KVFR Prevention Conditional Use Permit Comments

Project: 3 BR Custom Cuts

Permit#: CU-23-00001

Date: 02/22/2023

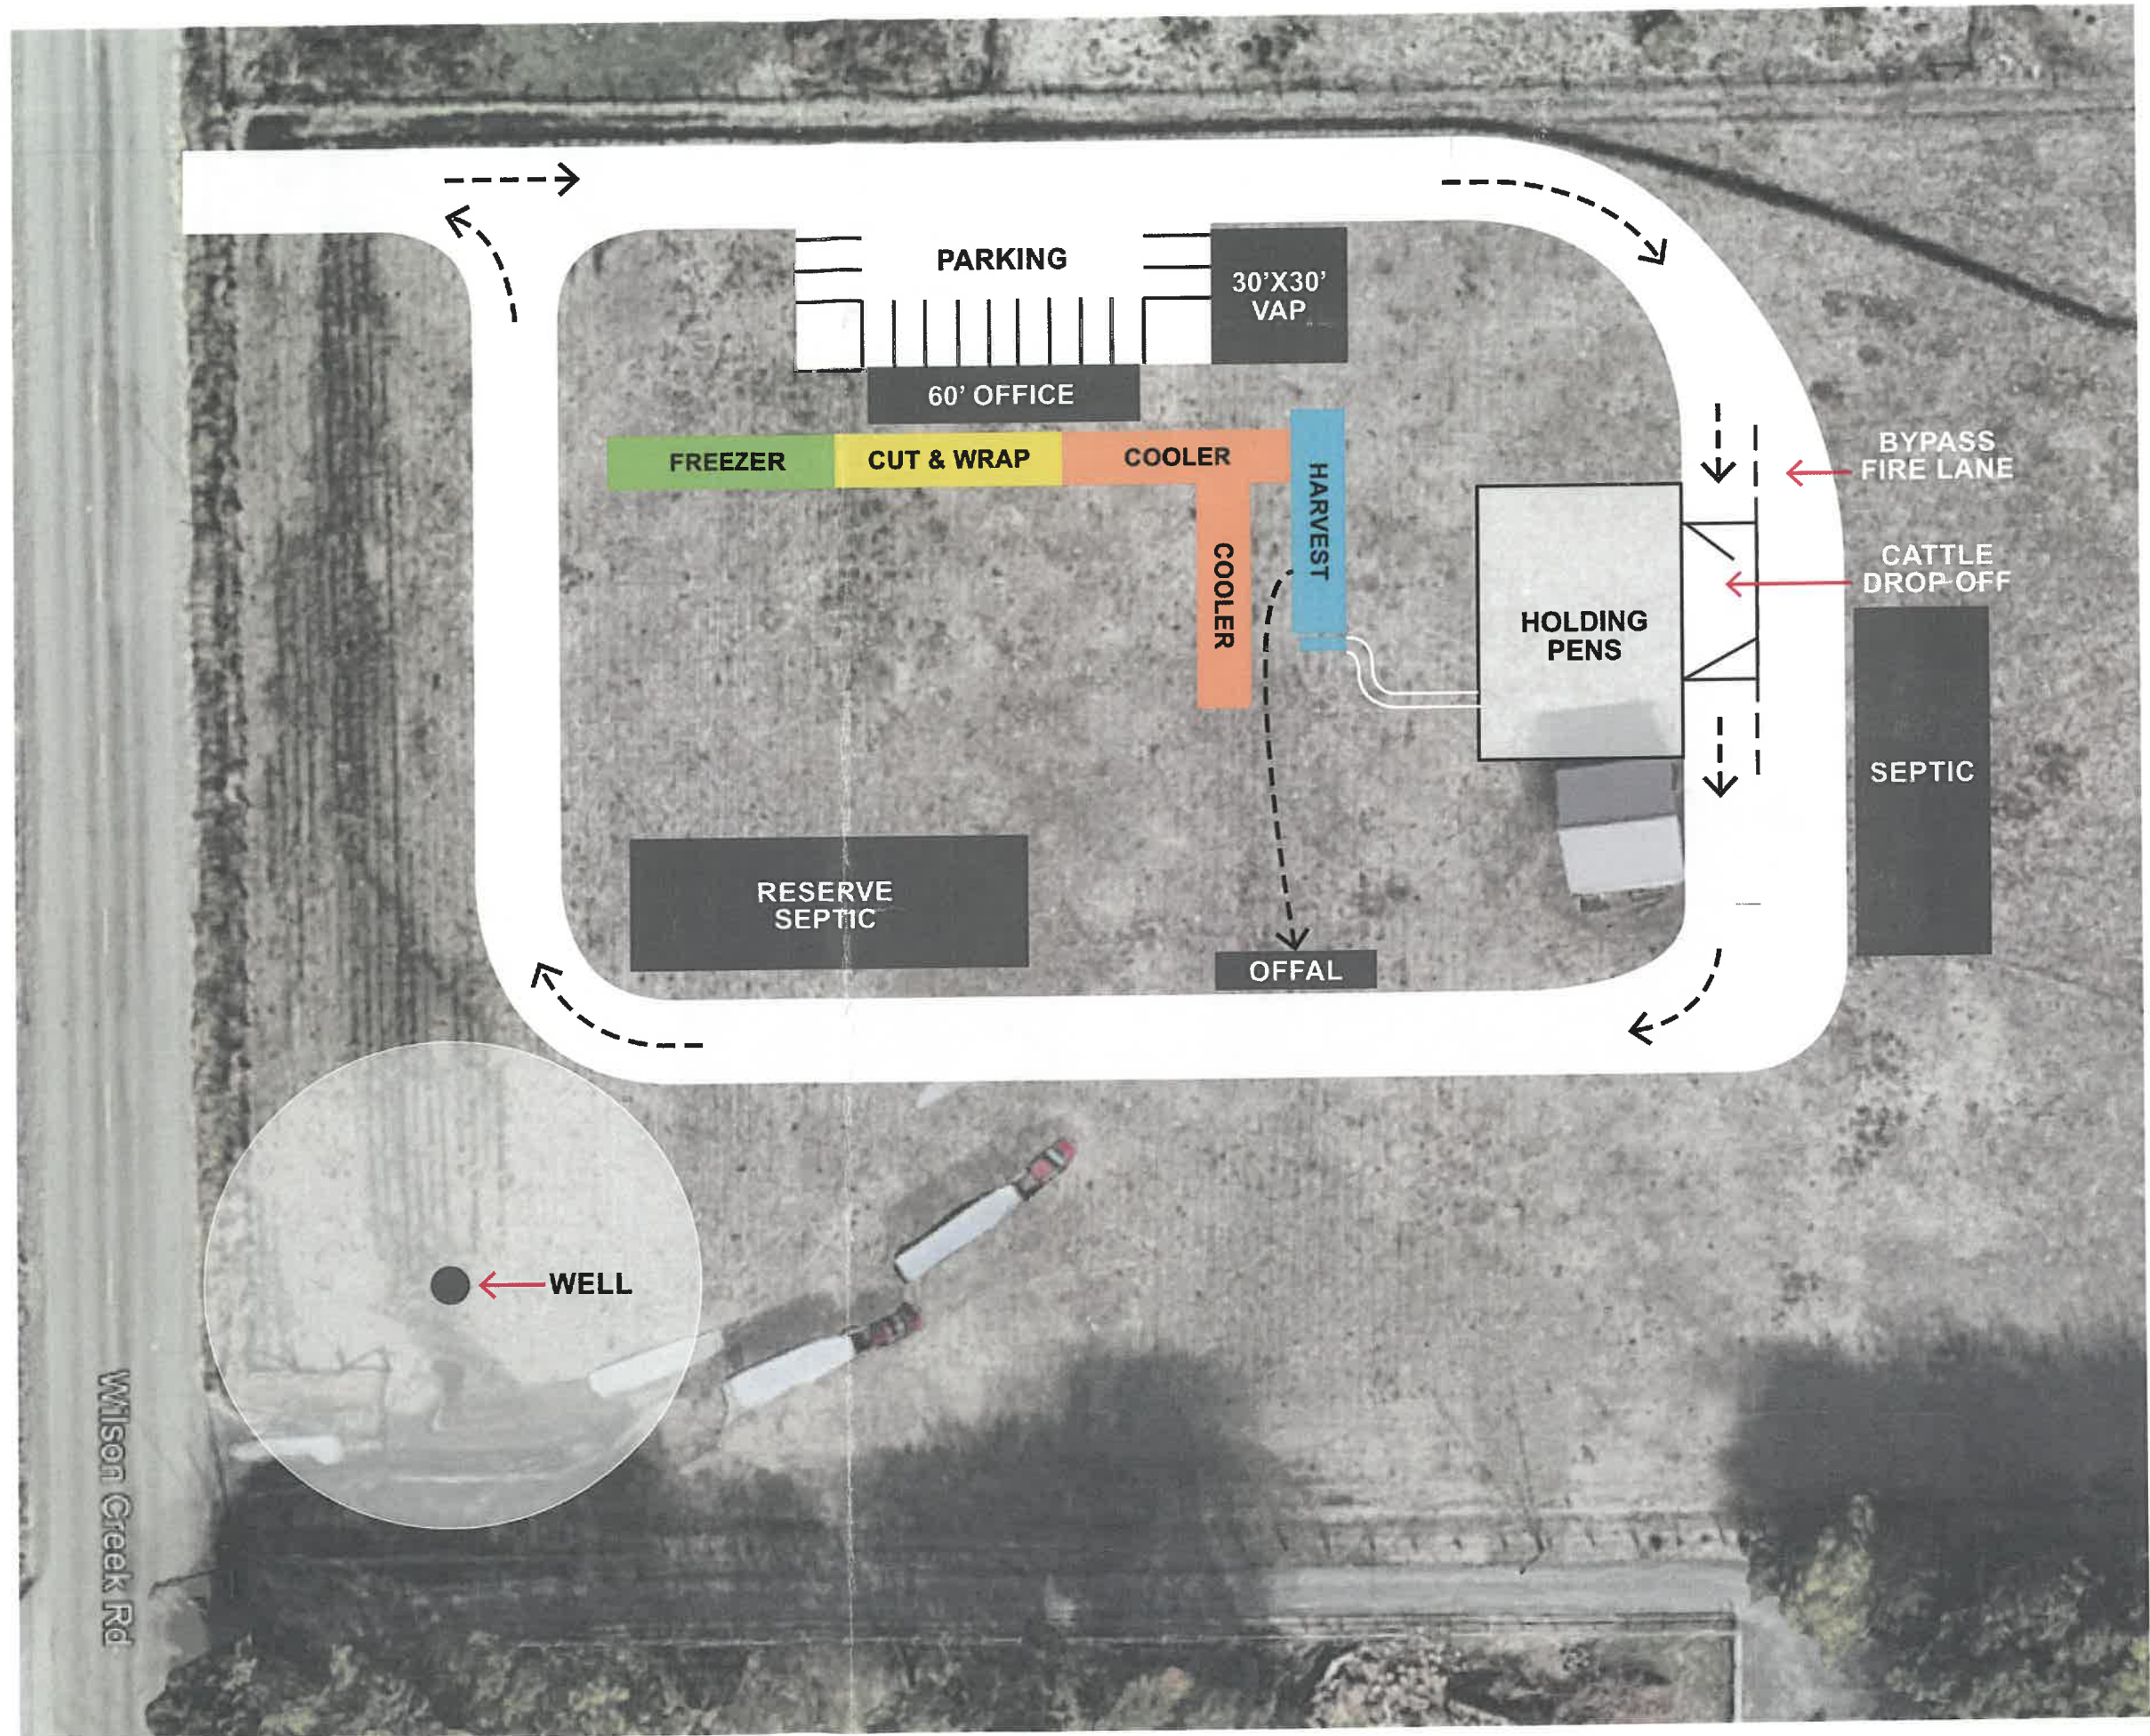
- Fire apparatus access roads exceeding 150' shall be provided with a temporary or permanent turnaround meeting the requirement 2018 IFC Appendix D. The proposed looped drive would meet this requirement.

- Sufficient parking, based on occupancy and to not interfere with fire lanes and building access.
- The IFC Appendix D requires the road be a minimum of 20' wide and capable of supporting an imposed load of at least 75,000 lbs.

- Building would be required to meet IBC and IFC requirements for the occupancy.
- Our standard turning radius is a minimum of 23' inside and 45' outside.
